13th May 2014

Reference A: Application MP 10_0135, Capital II Wind Farm

In regards to Reference A, the proponent seeks approval for a modification to the Project Layout in the Environmental Assessment. The proponent wishes to adjust the route of the transmission line outlined in the Environmental Assessment to that shown on the attached map (marked by the dashed green line). This change will affect Figures 25, 27, 28, 29, 31 and 32 in the Environmental Assessment.

Figure 25: Proposed 55 turbine layout 'A'

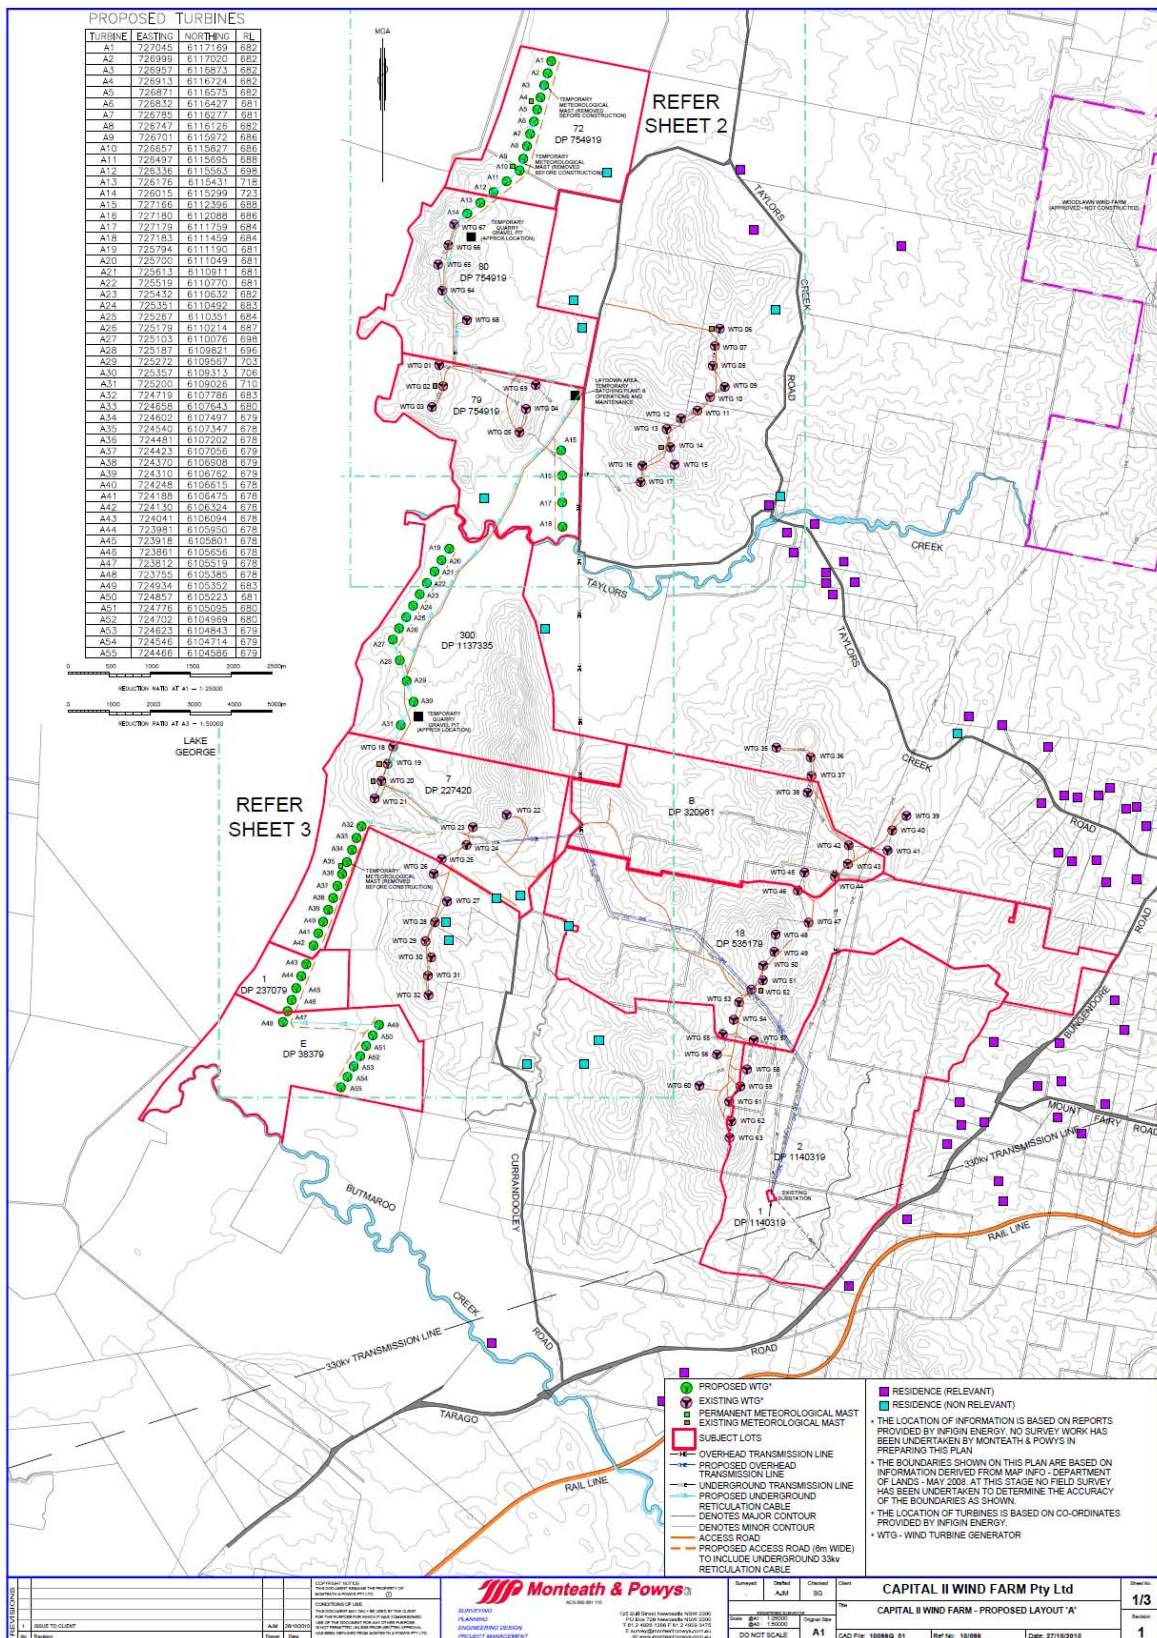
The Proponent also seeks approval for a minor modification to the environmental assessment such that the passage "The overhead transmission lines will follow the alignment of the existing overhead lines and connect with underground cabling (as shown on Project Layouts Figures 25 and 29)" on page 102 of the Environmental Assessment be removed.
